National Infrastructure Planning  
Temple Quay House  
2 The Square  
Bristol, BS1 6PN

Our Ref: EN010127

### **Application by Mallard Pass Solar Farm Limited for an Order Granting Development Consent for the Mallard Pass Solar Project**

#### **Advice following issue of decision to accept the application for examination**

No dimensions are to be scaled from this drawing.  
All dimensions are to be checked on site.  
Area measurements for indicative purposes only.

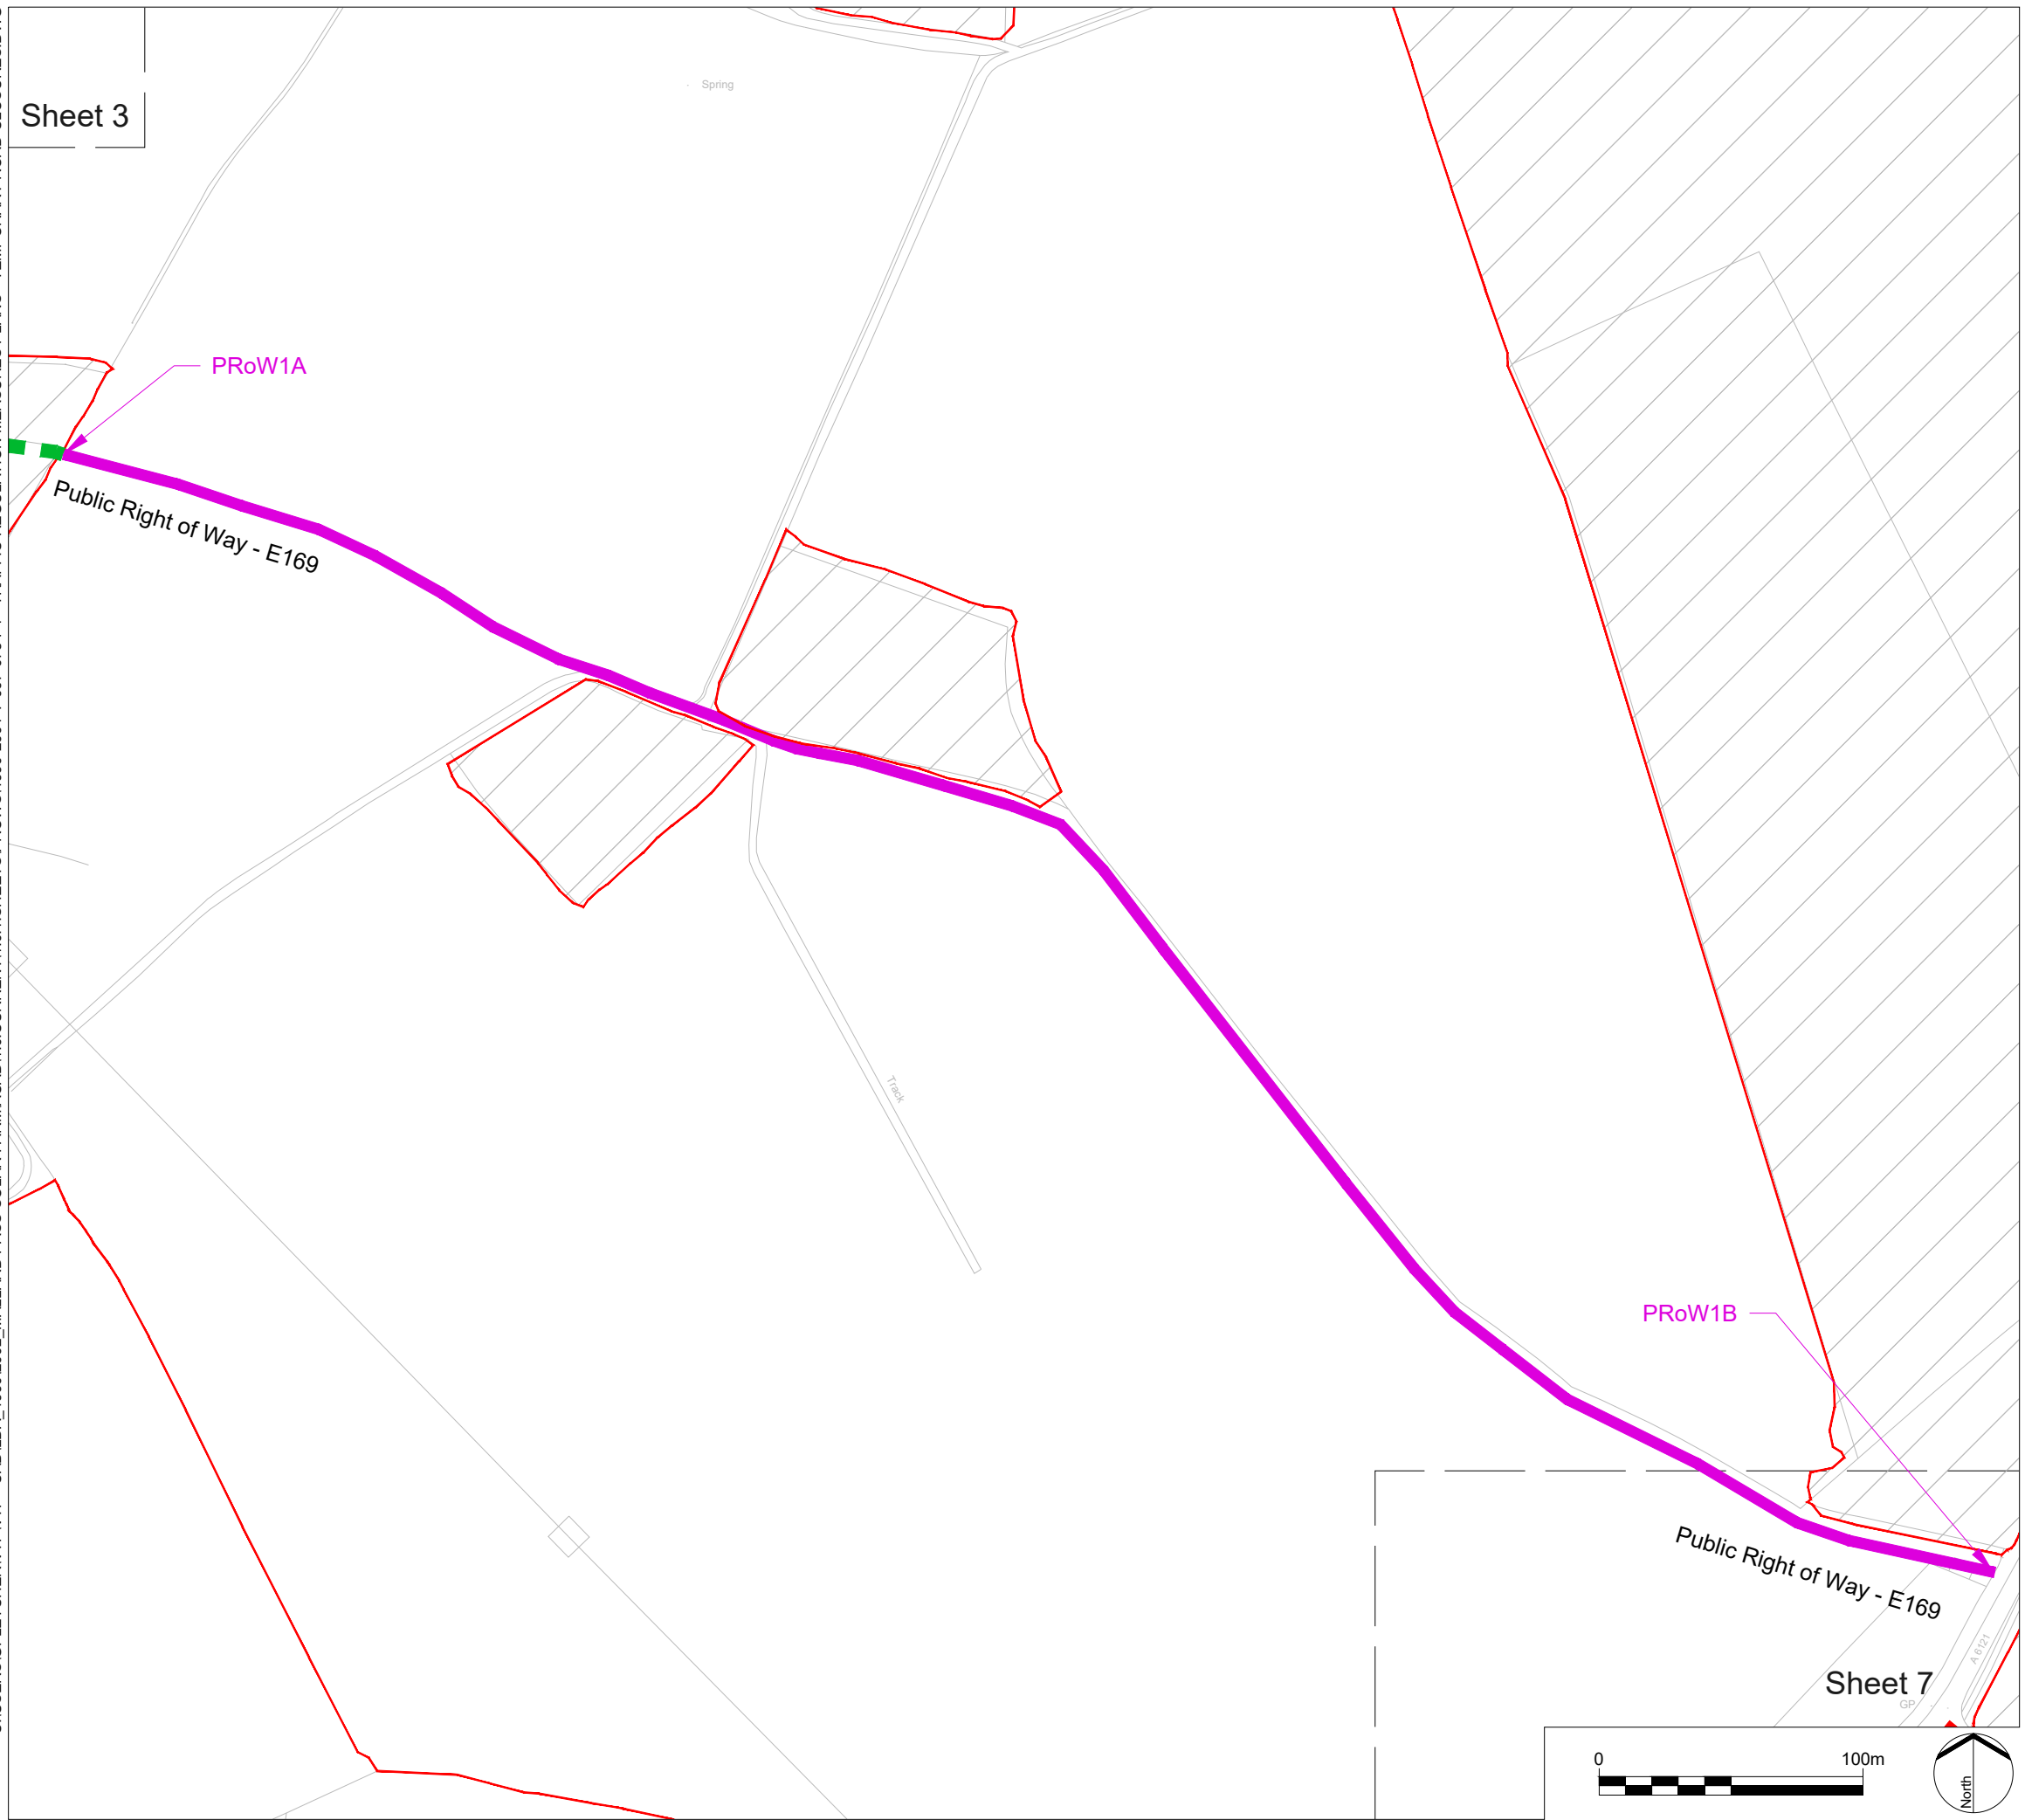
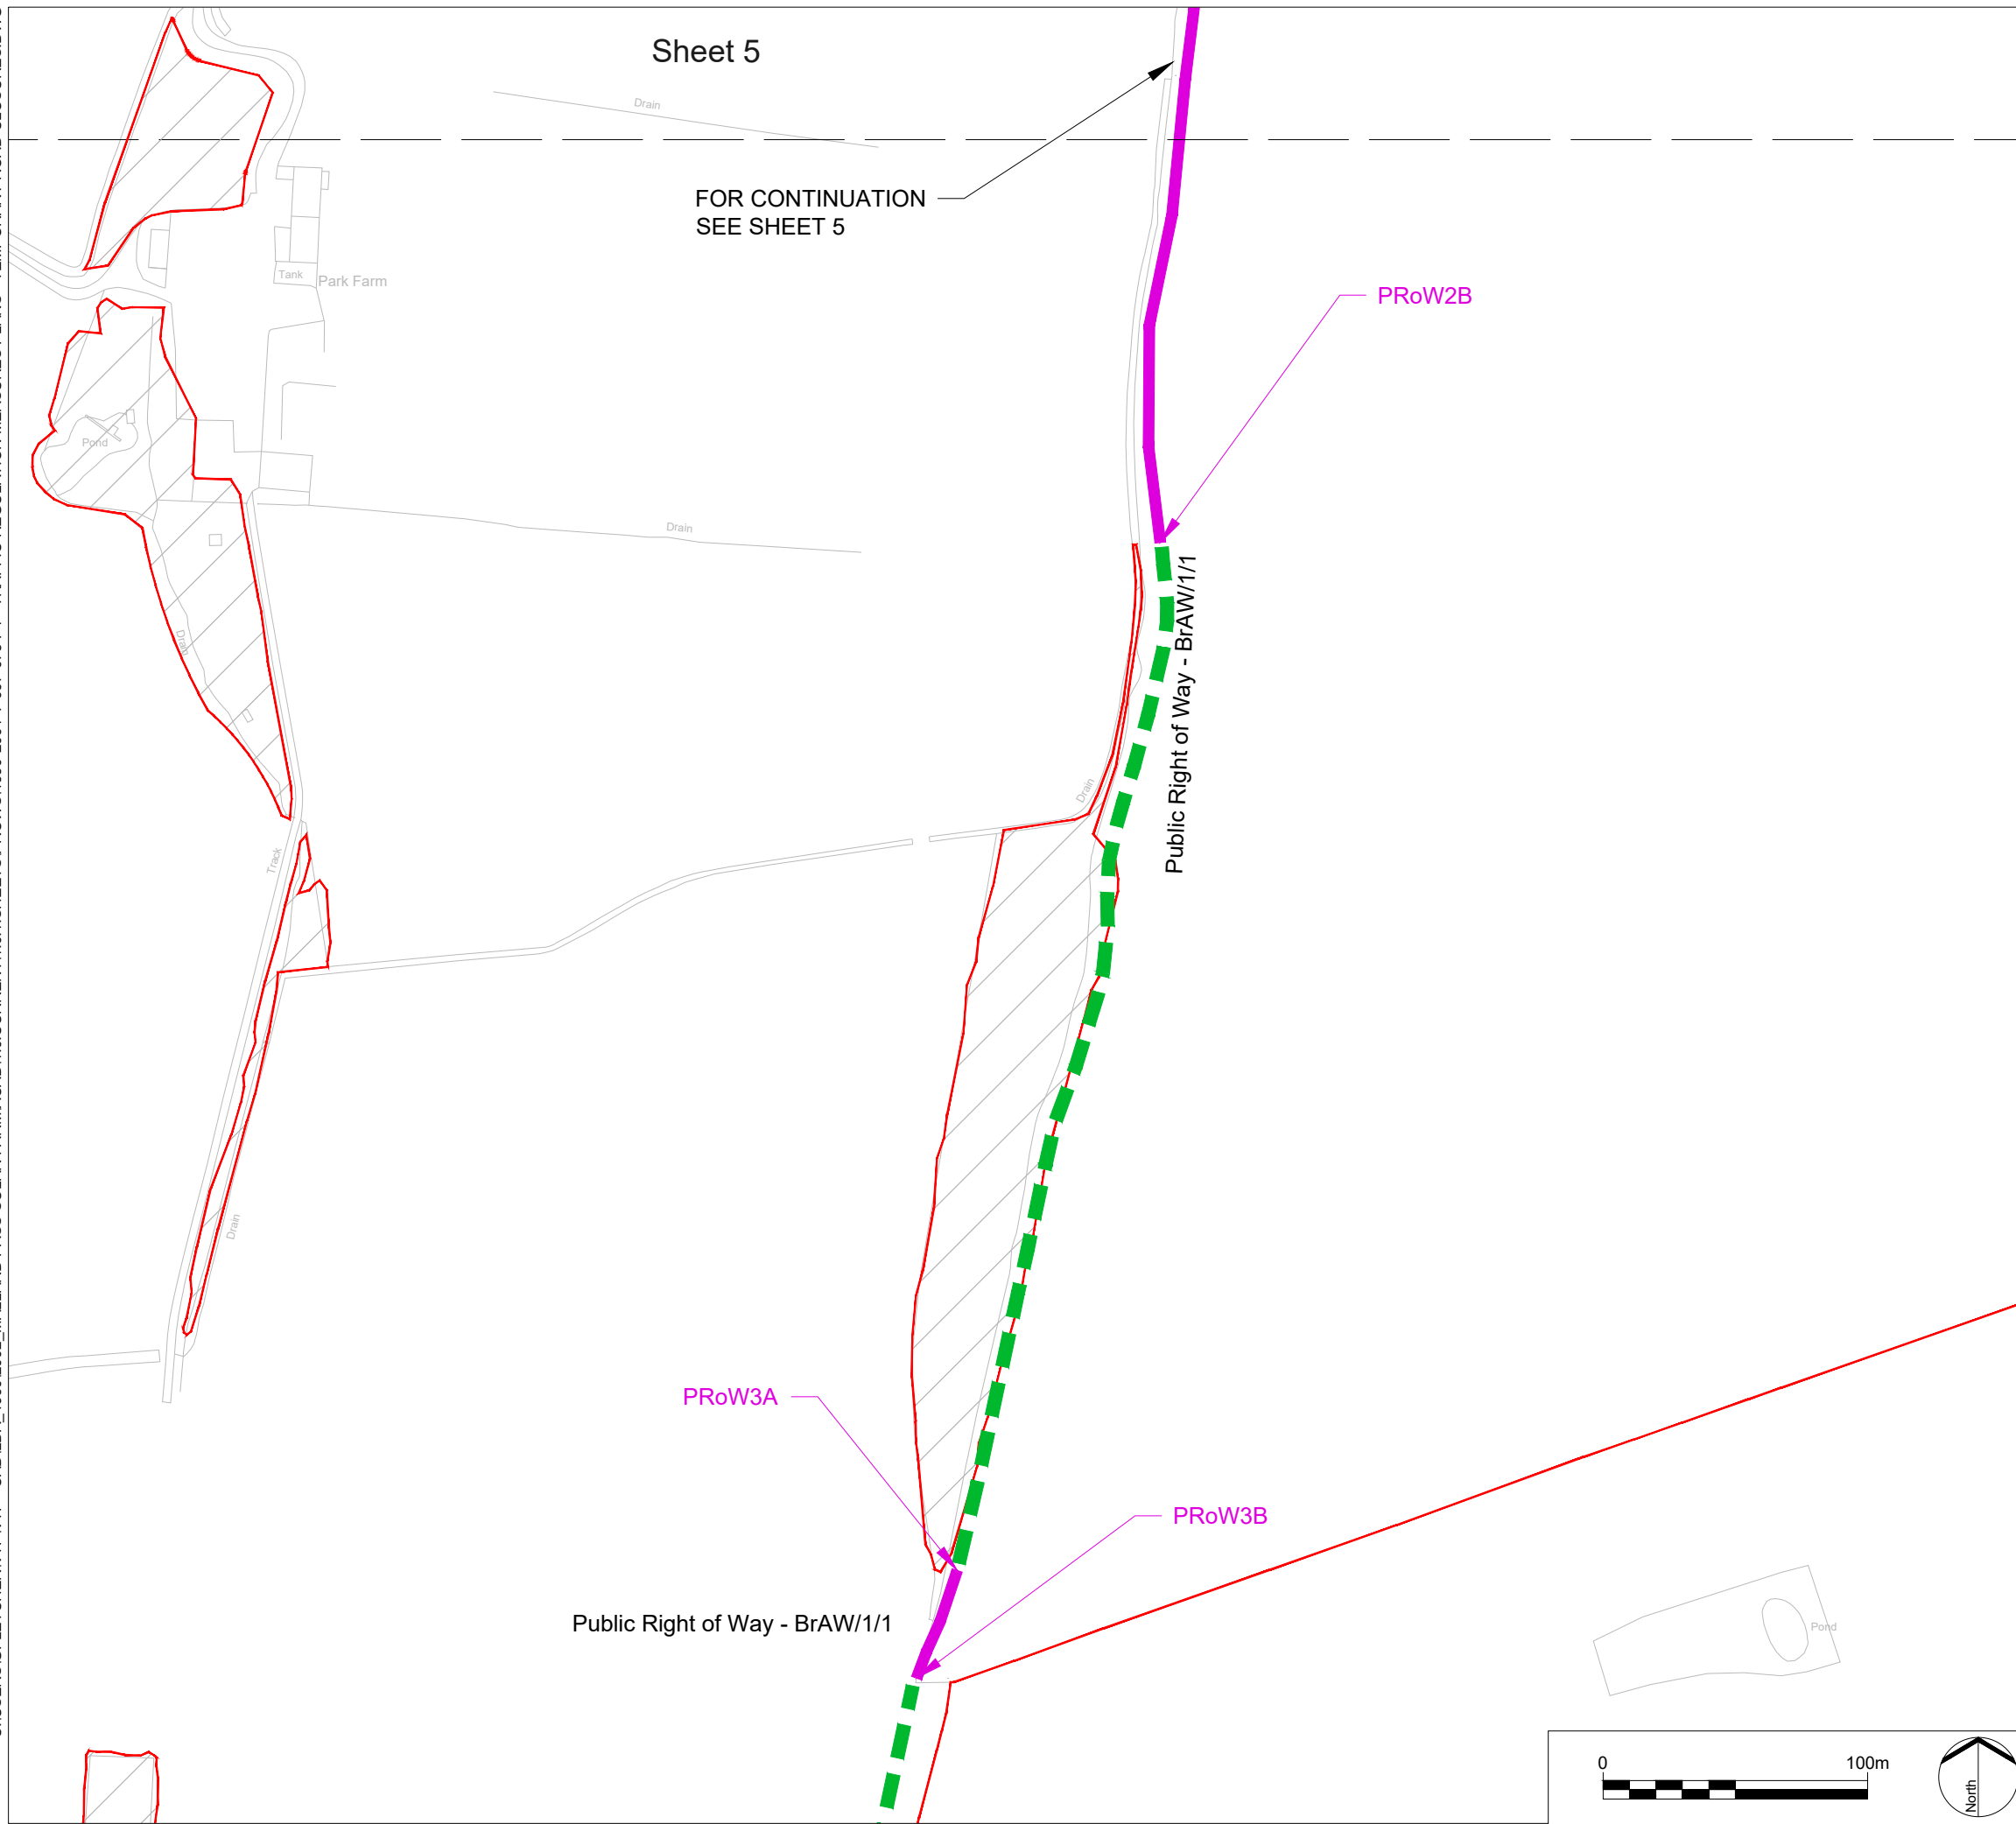
For clarity and to help understanding, existing public footpaths (public rights of way) should be marked and the plans more clearly notated to reflect the proposals, including differentiating works to footpaths and roads.
